CITY OF ALBUQUERQUE

May 30, 2018

RE: Worthan Residence
7908 Shiprock Ct. NW
Lot 21 Block 7 Volcano Cliffs Sub. SAD 227
Grading and Drainage Plan
Engineers Stamp Date 5/25/18 (E10D046)

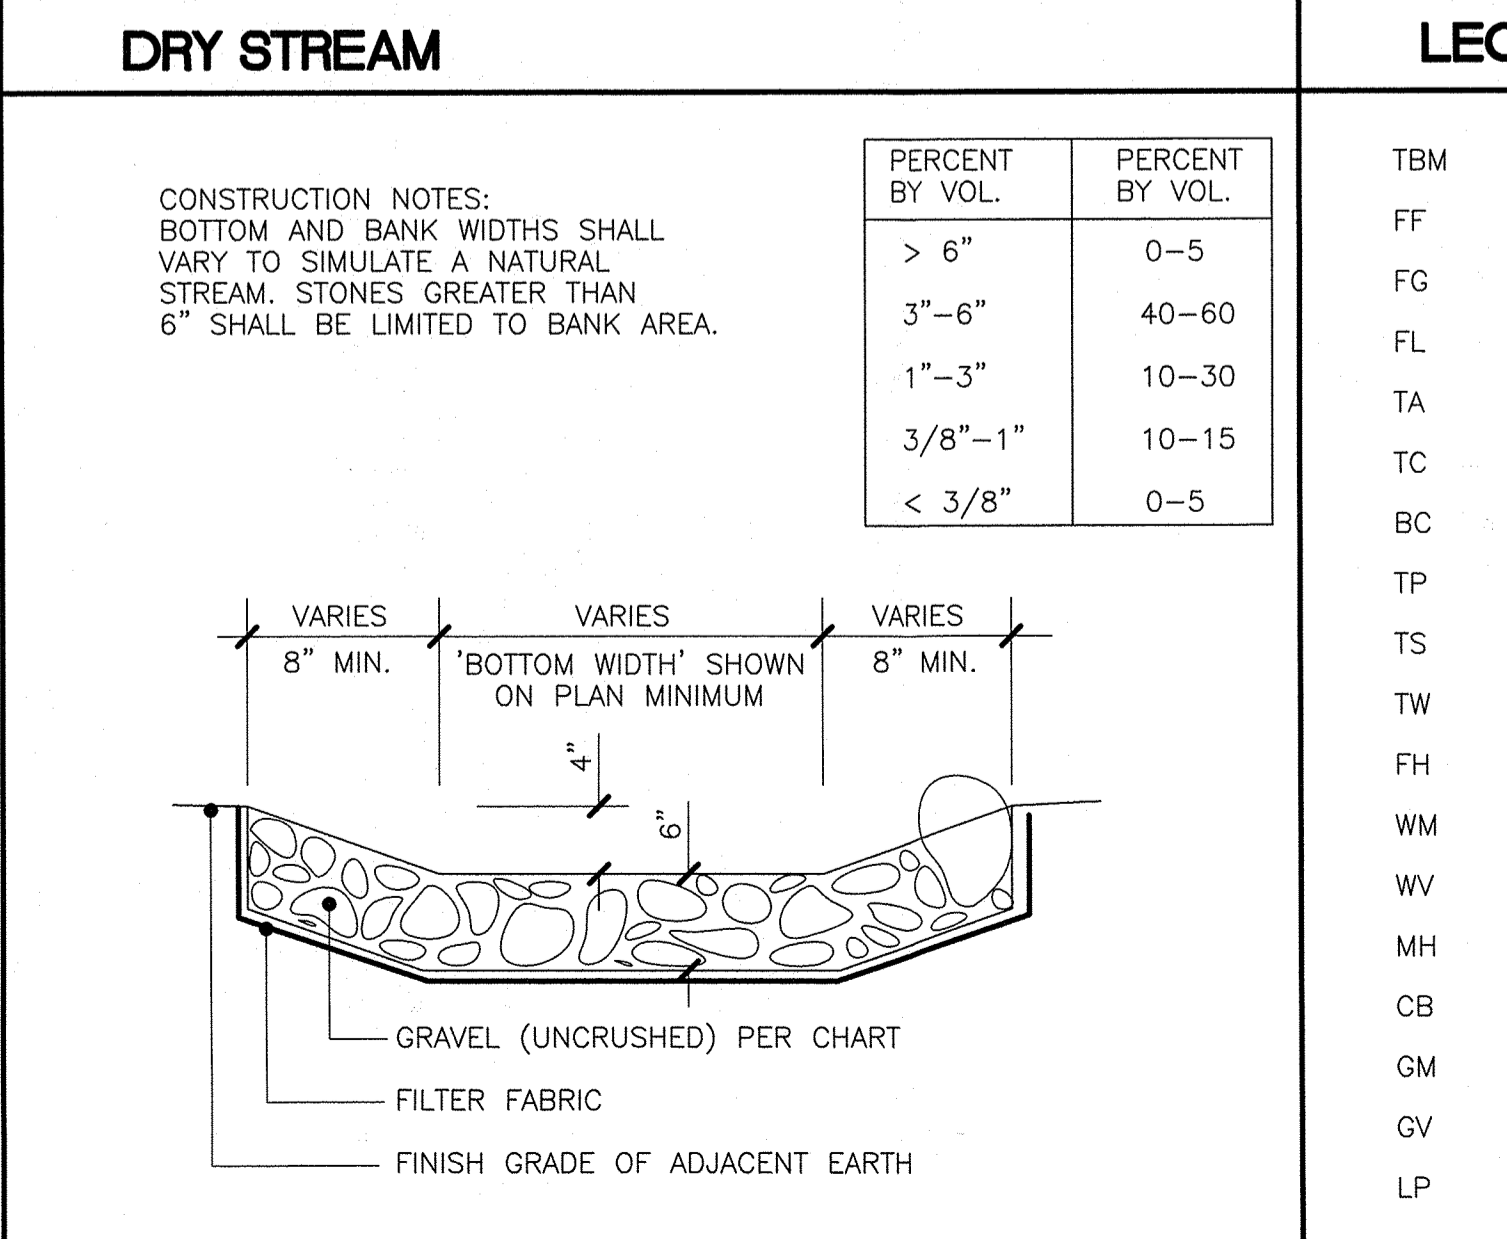
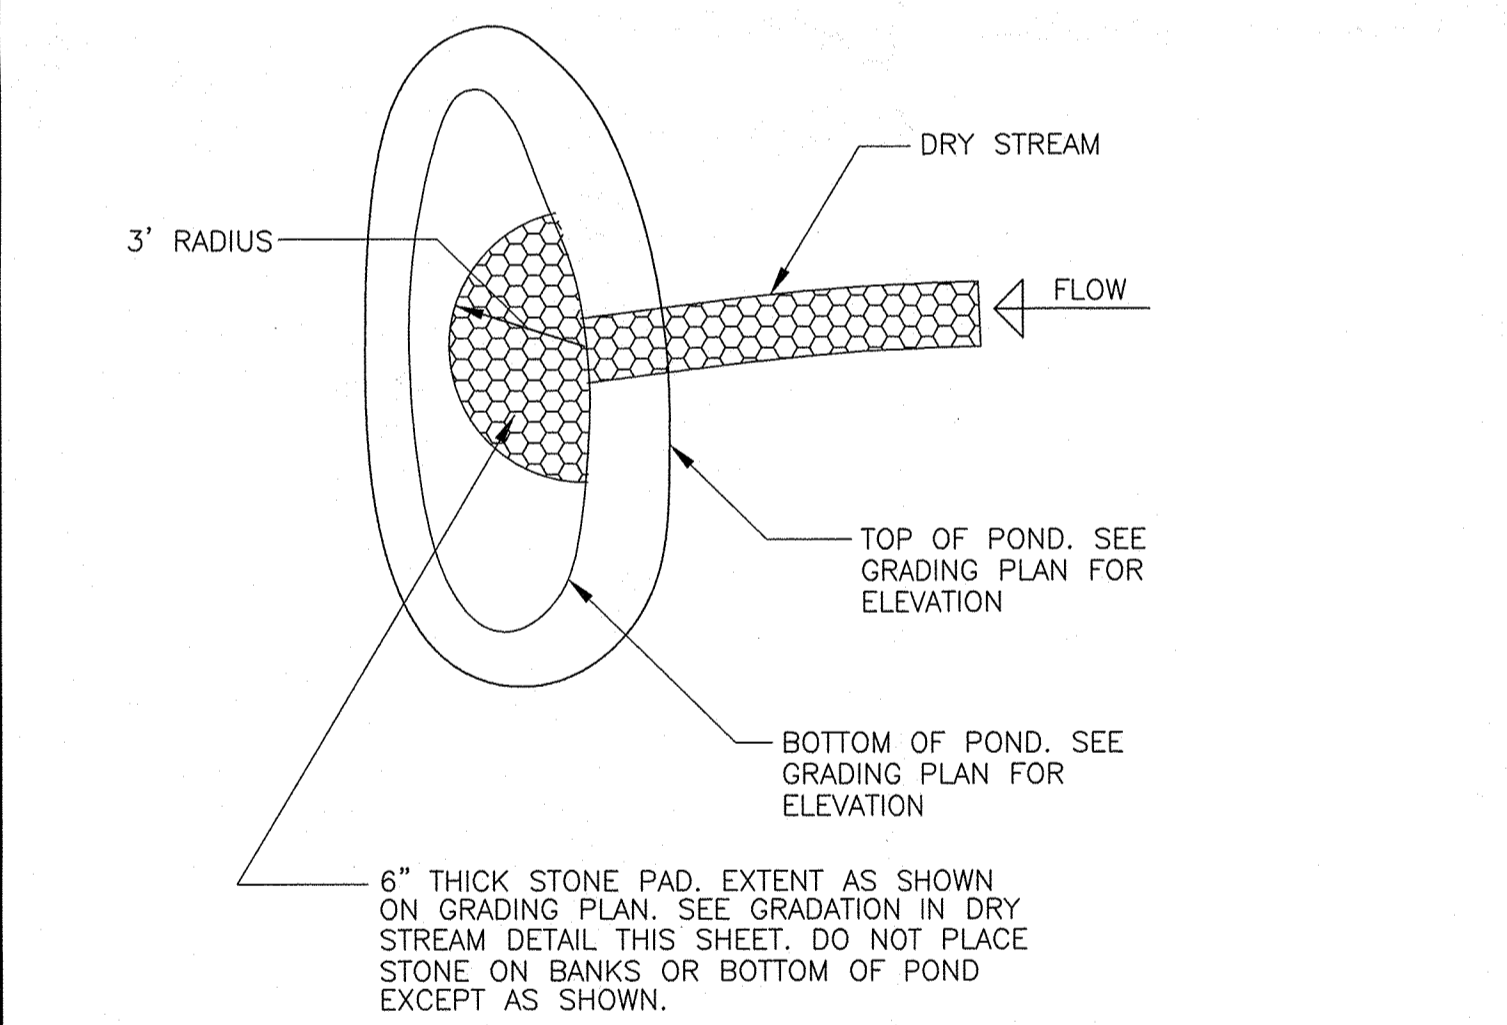
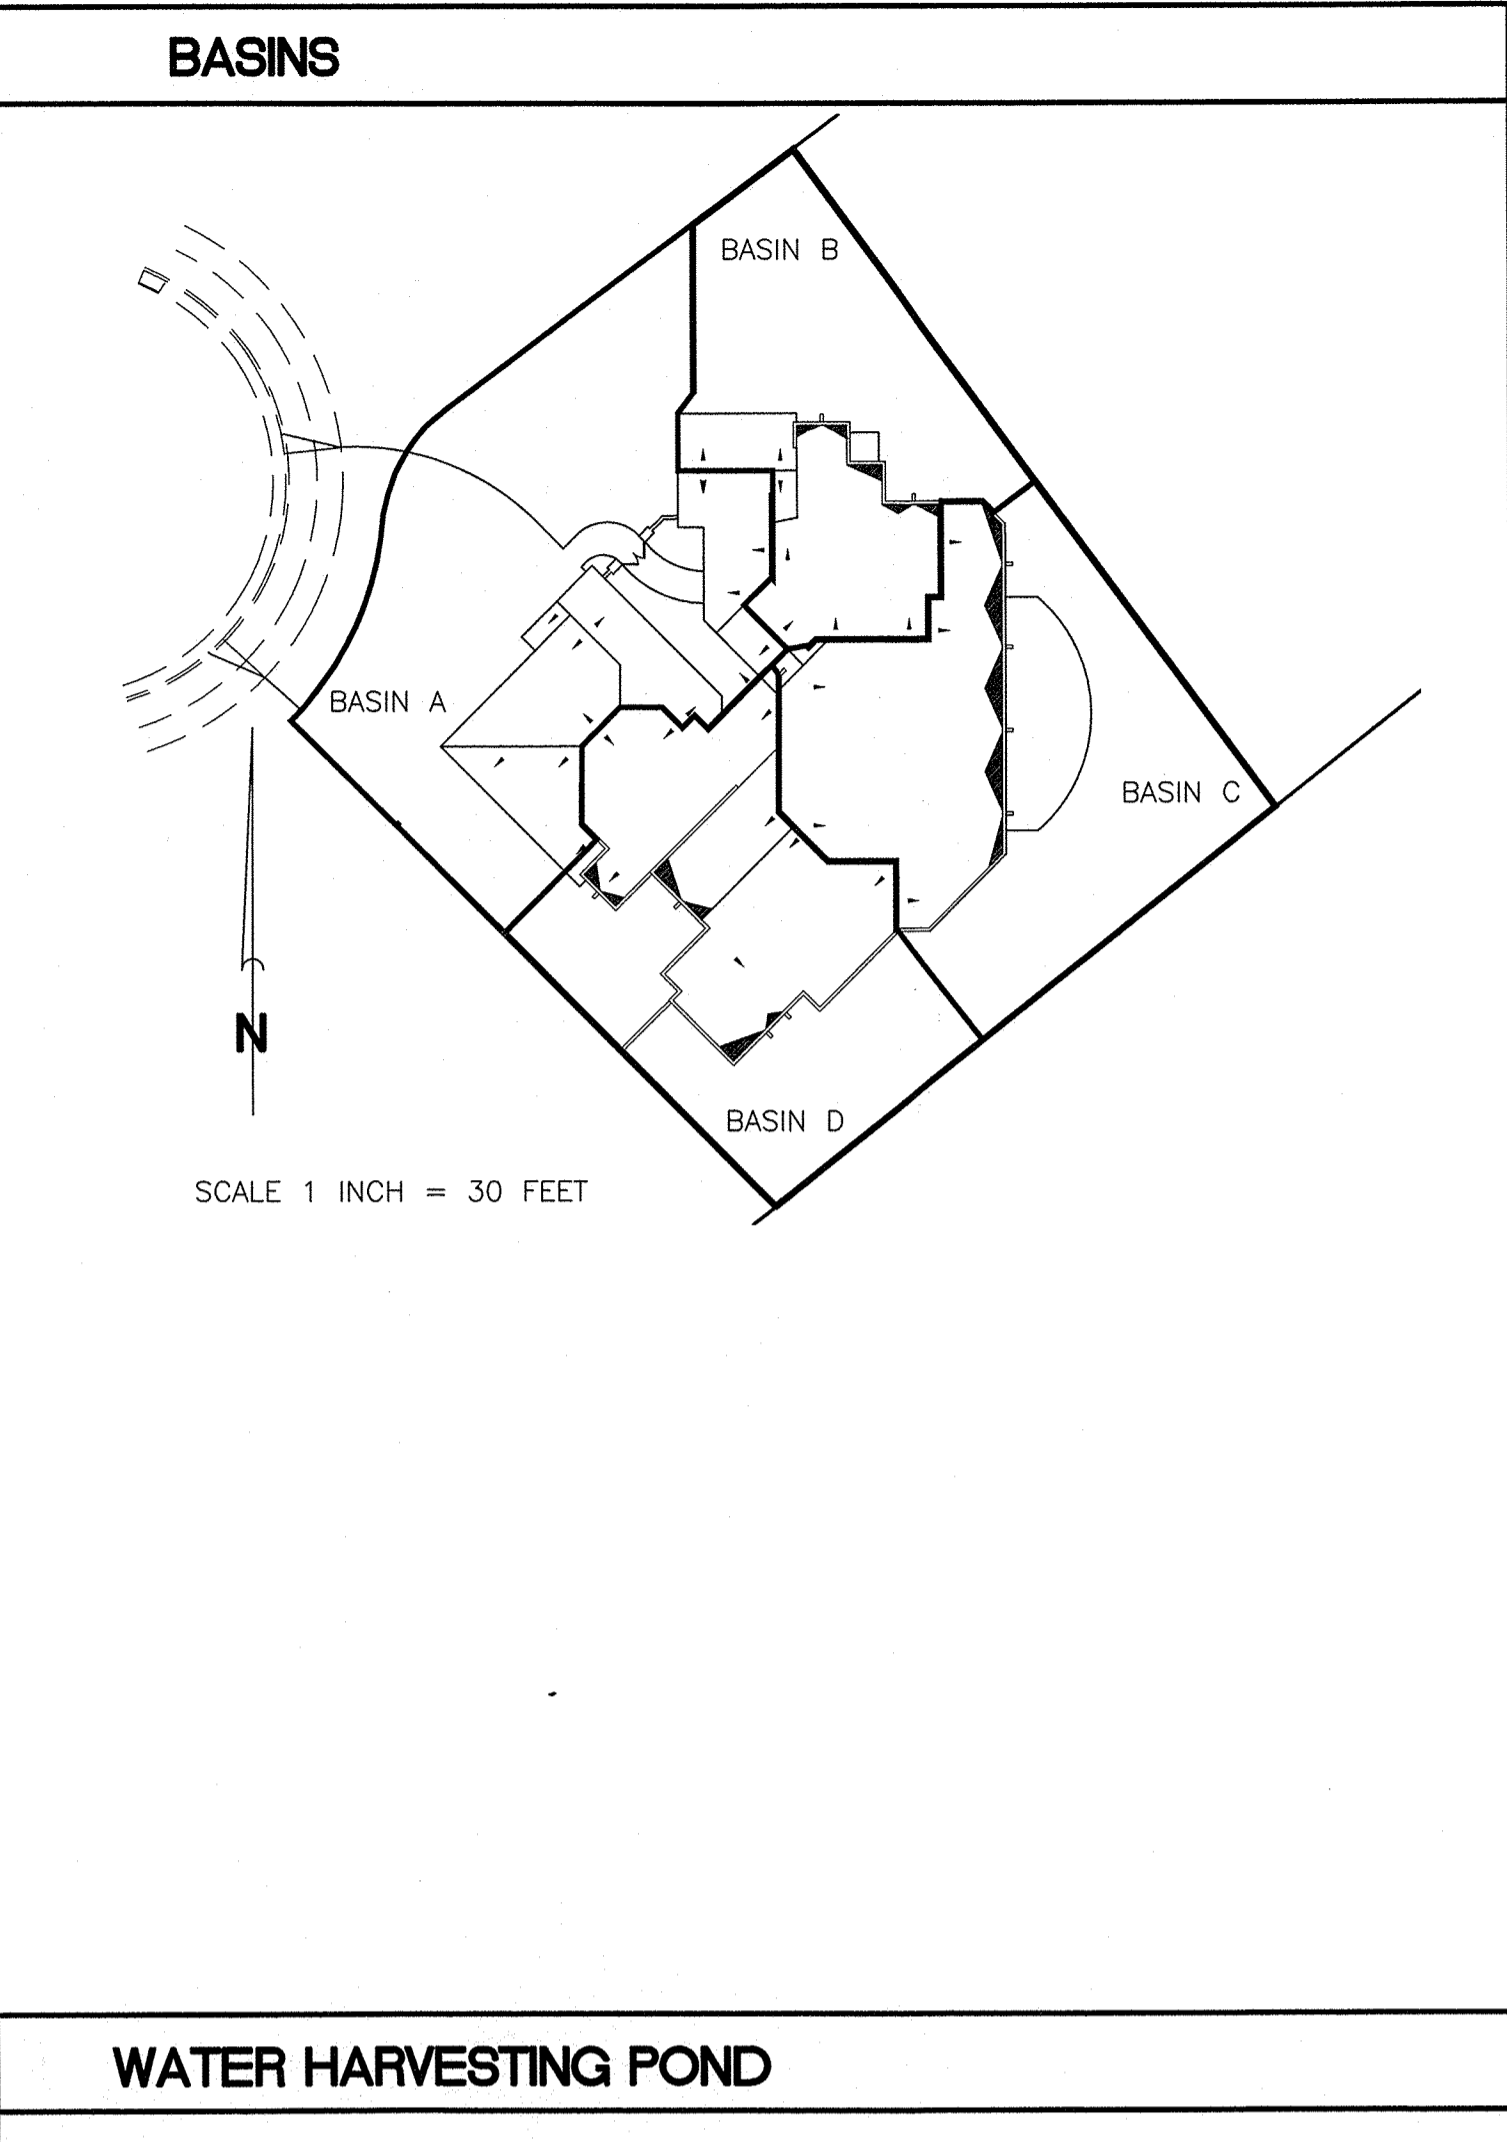
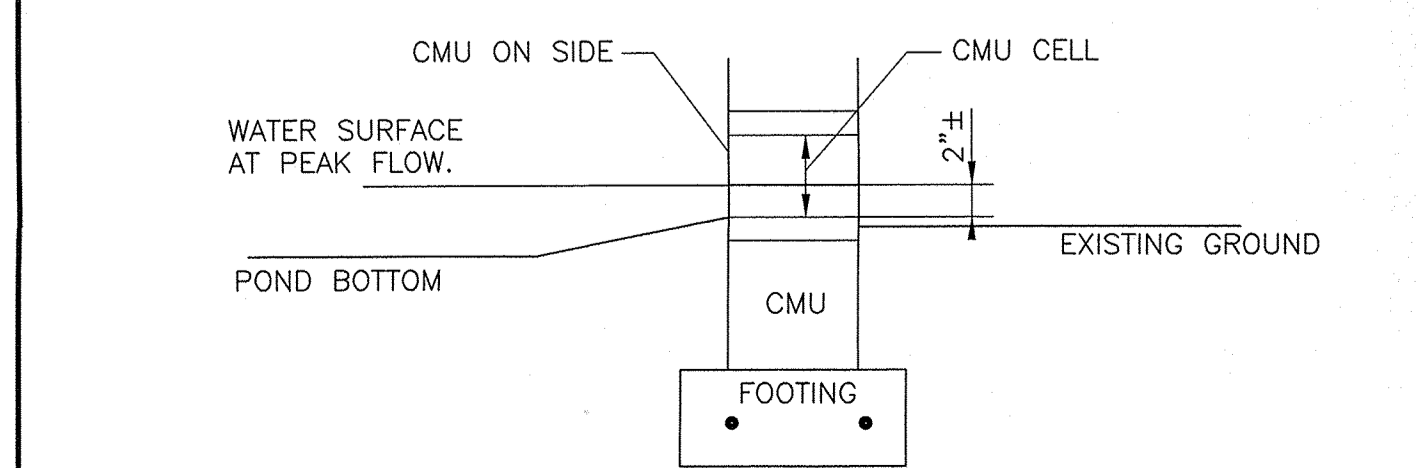
- Provide a note 10 in the SW yard wall.
- Remove the Engineers Certification block or draw an X signifying this block is omitted.
- Provide sheet 13 of the architectural plans for review.
